Current Zoning: N1-B (neighborhood 1 – B)
Proposed Zoning: N2-A(CD) (neighborhood 2 – A, conditional)

Approximately 3.726 acres located along the south side of The Plaza, east of Aintree Road, and west of Lakedell Drive.

The petition proposes to allow the development of multi-family attached residential units on parcels developed with one single family home.

Drakeford Communities

**RZ.01**

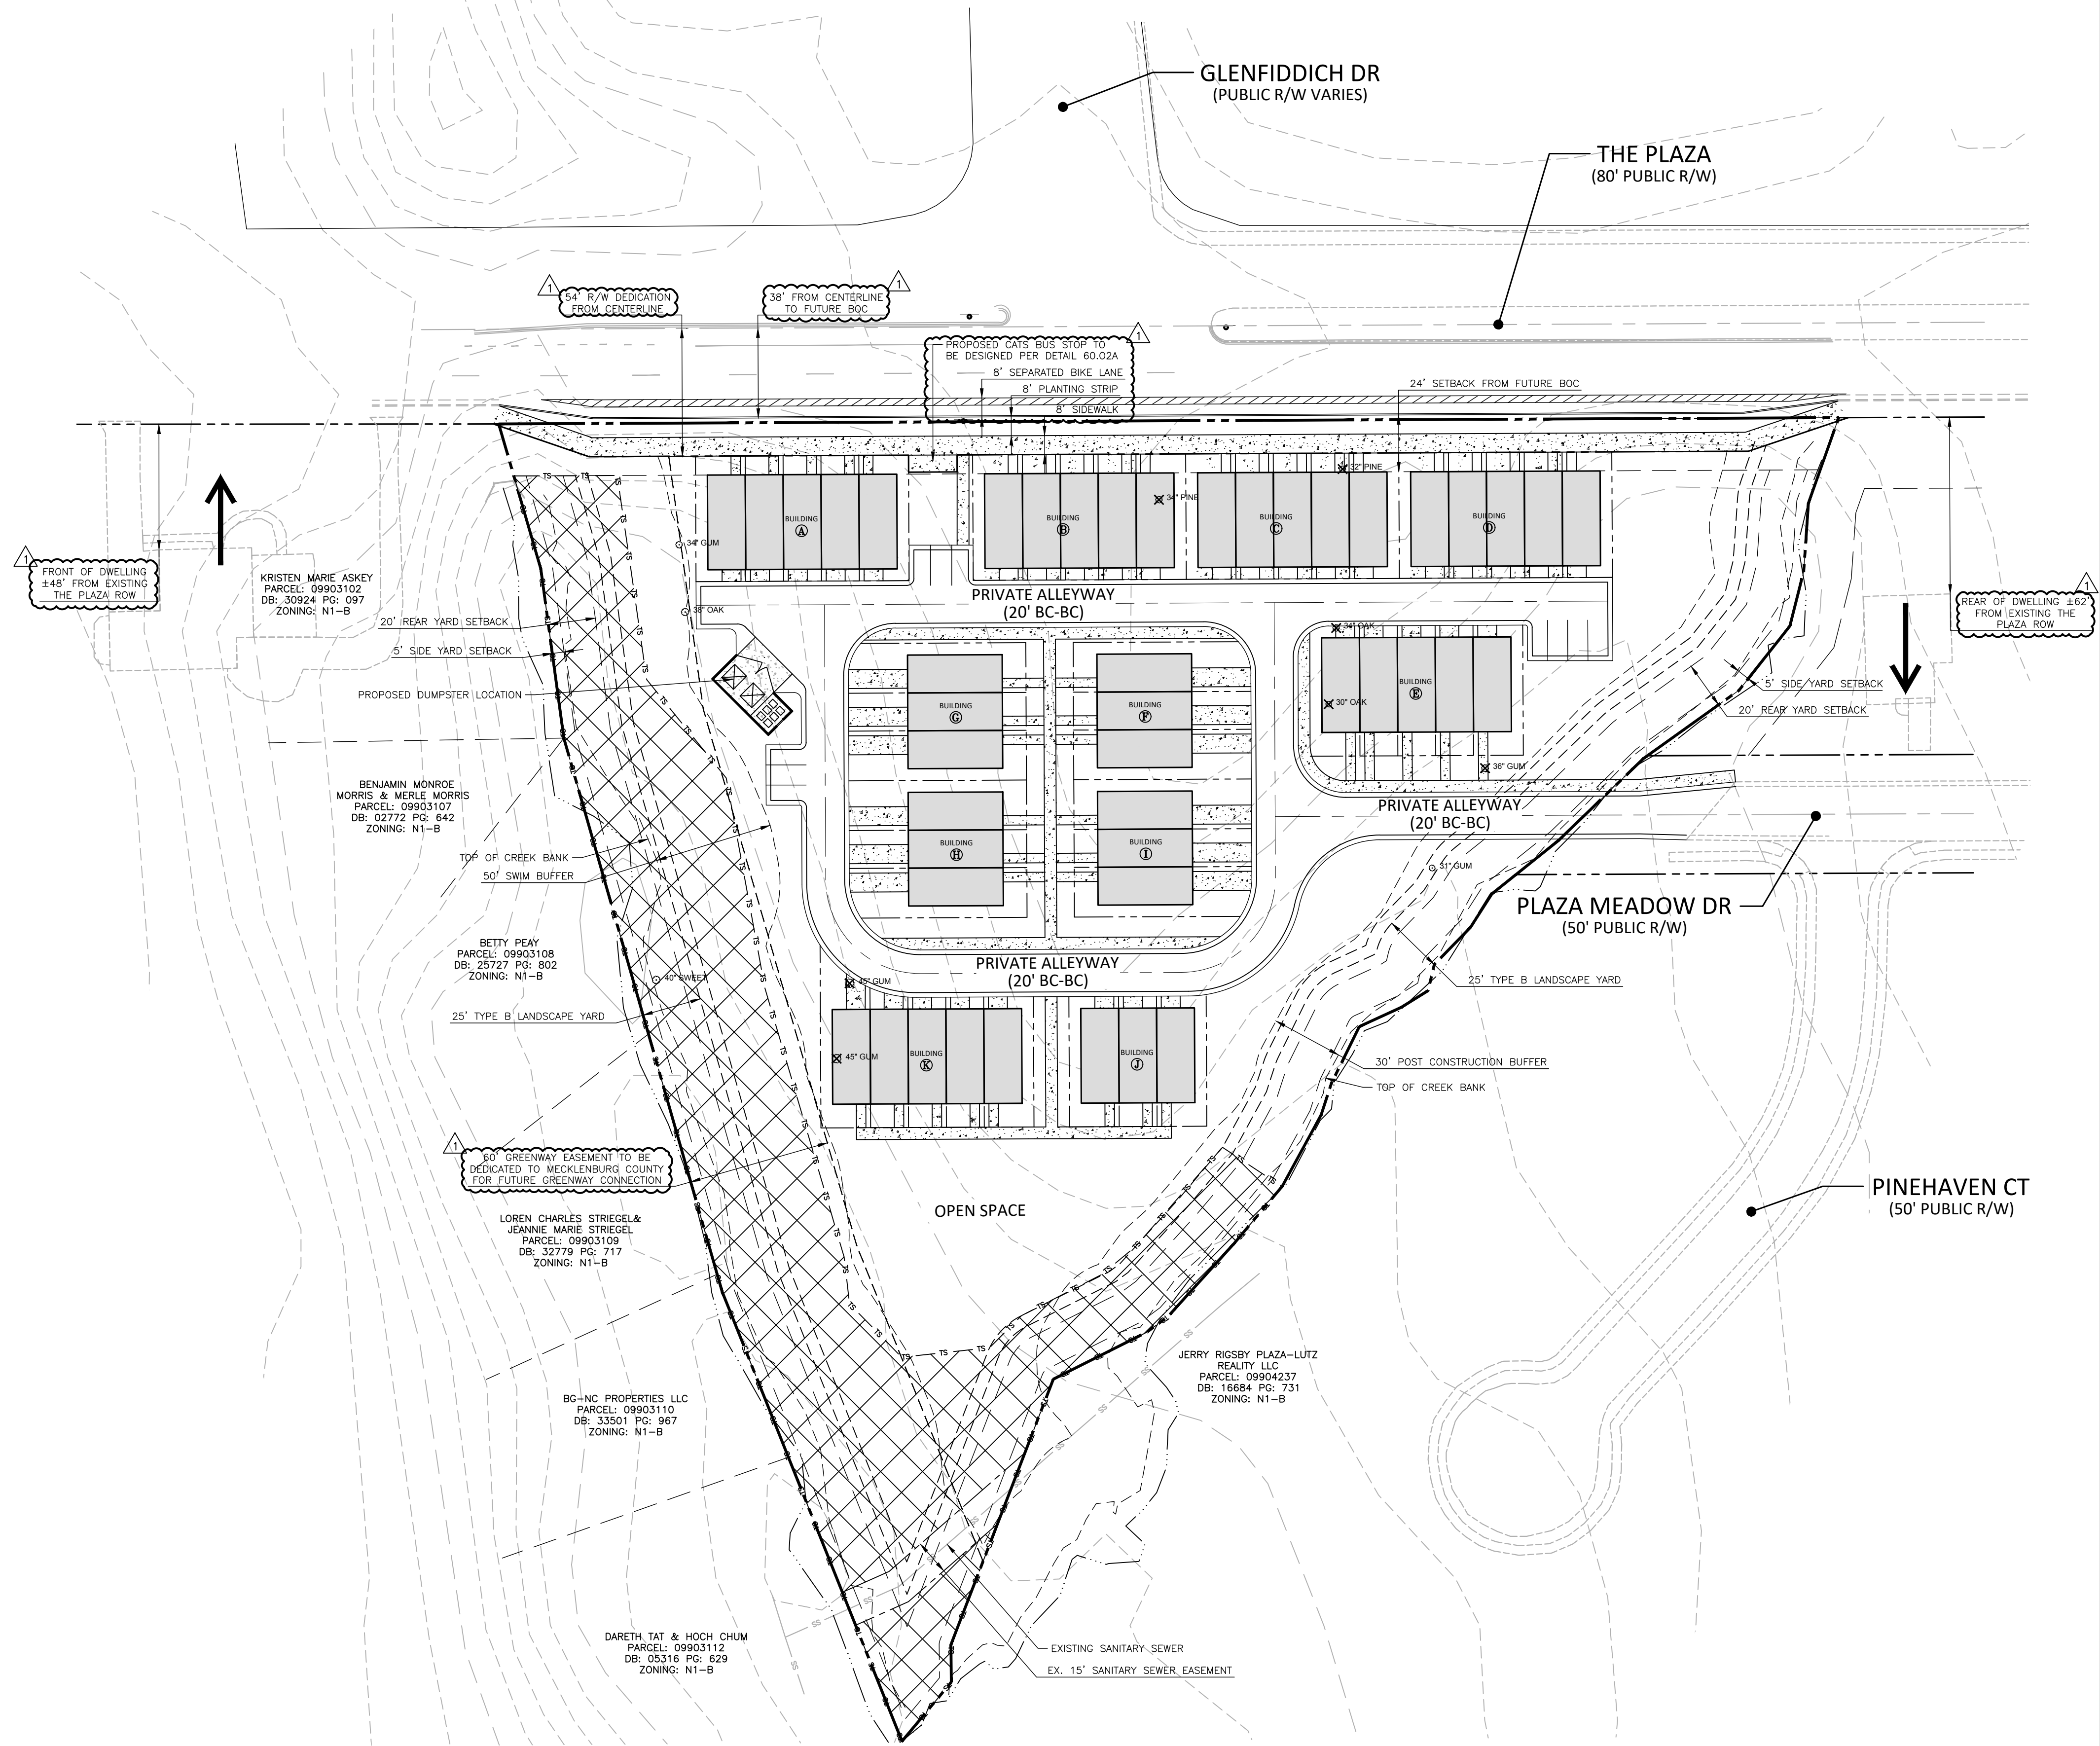
1. Provide a tree survey to Urban Forestry and show location of all existing heritage trees on the site plan.
